September 4, 2024

RE: Responses to Comments
Dutch Bros Coffee (CO0907)
5810 Omaha Boulevard, Colorado Springs, Colorado
Our Job No. 23098

Barghausen Consulting Engineers, Inc. has revised the plans and technical documents for the above-referenced project in accordance with your comment letter dated July 25, 2024. Enclosed are the following documents for your review and approval:

Job Number: 23098  
Sheet: 11  
2019 DCA  
Financing USA, LLC

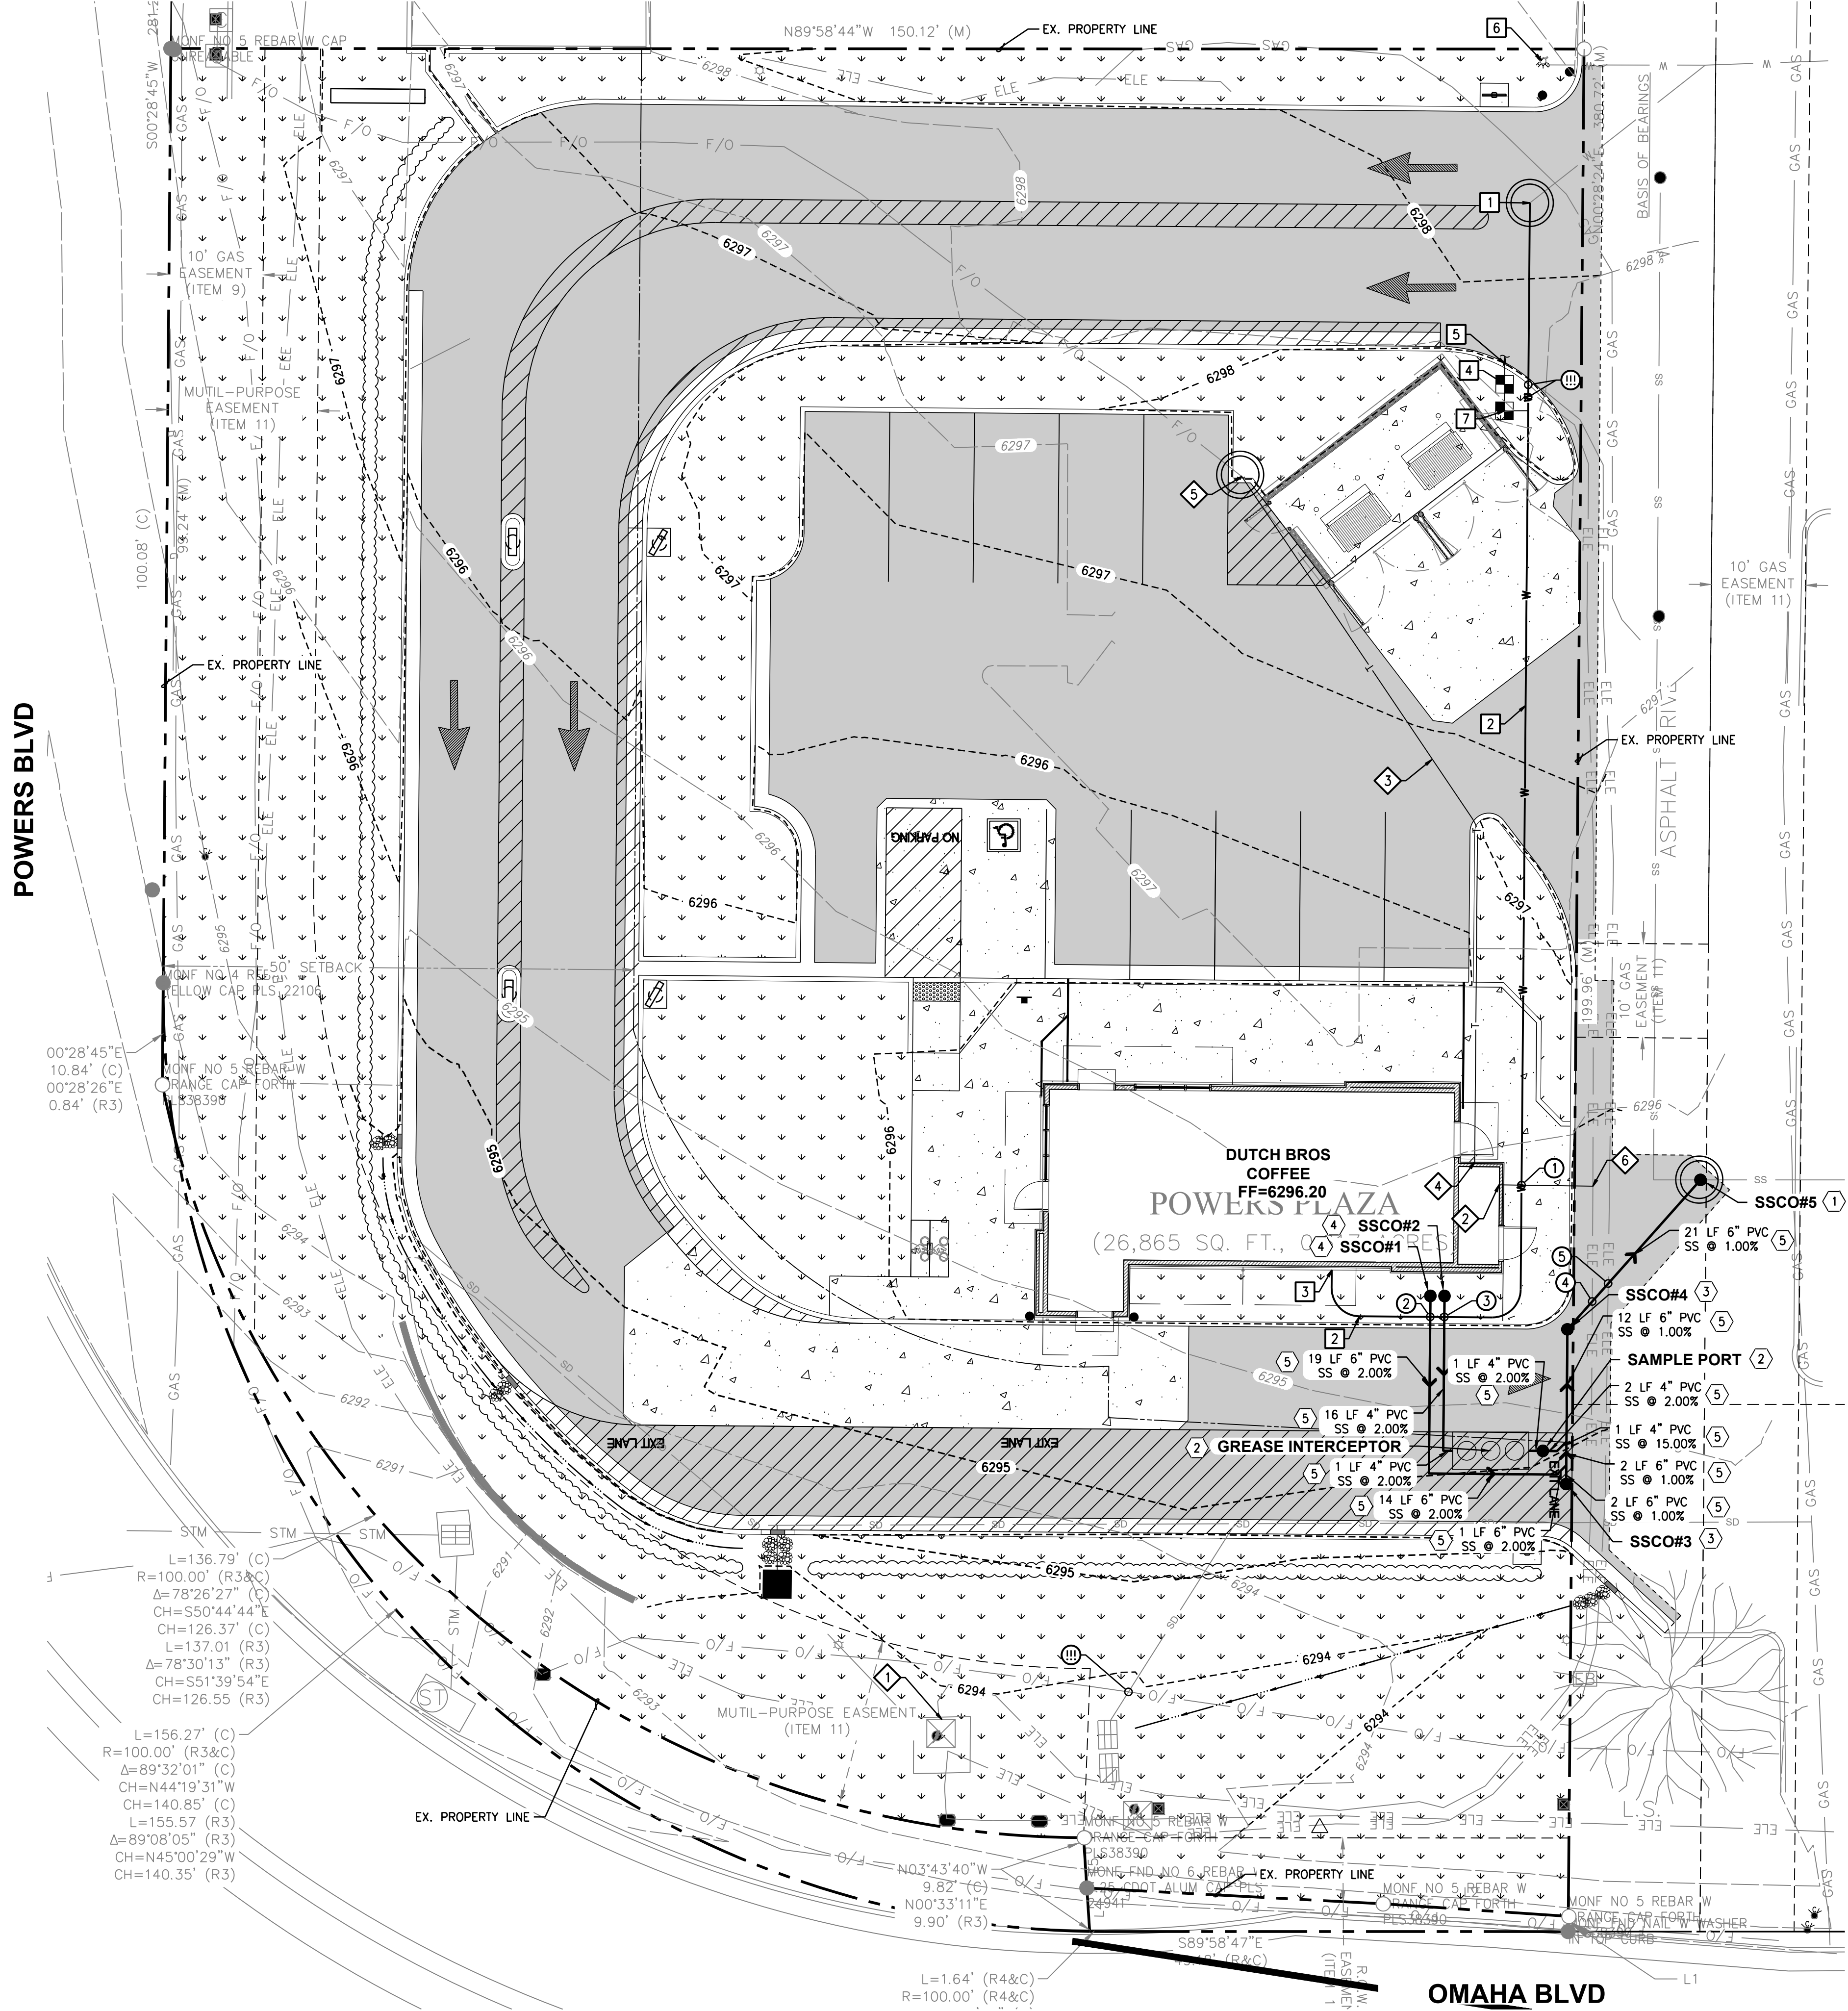
8. *On page 11 of "grading plan", your Utility plan needs the following changes for final approval:
under sanitary sewer construction notes, the sanitary sewer cleanout needs to specify that it will in in accordance with Cherokee standard as well. Our standards are mostly in line with CSU water/wastewater Line extension service standards.*

On the Utility crossing table, your electrical clearance with the domestic water is correct, however, your sewer and potable-water need to have 18" of vertical separation at the crossings per Cherokee Metropolitan District standard.

attached is a written-on Utility plan with these needed changes marked

Response: The vertical clearance between sewer and potable water was revised to 18 inches on the Utility Plan Sheet 11.
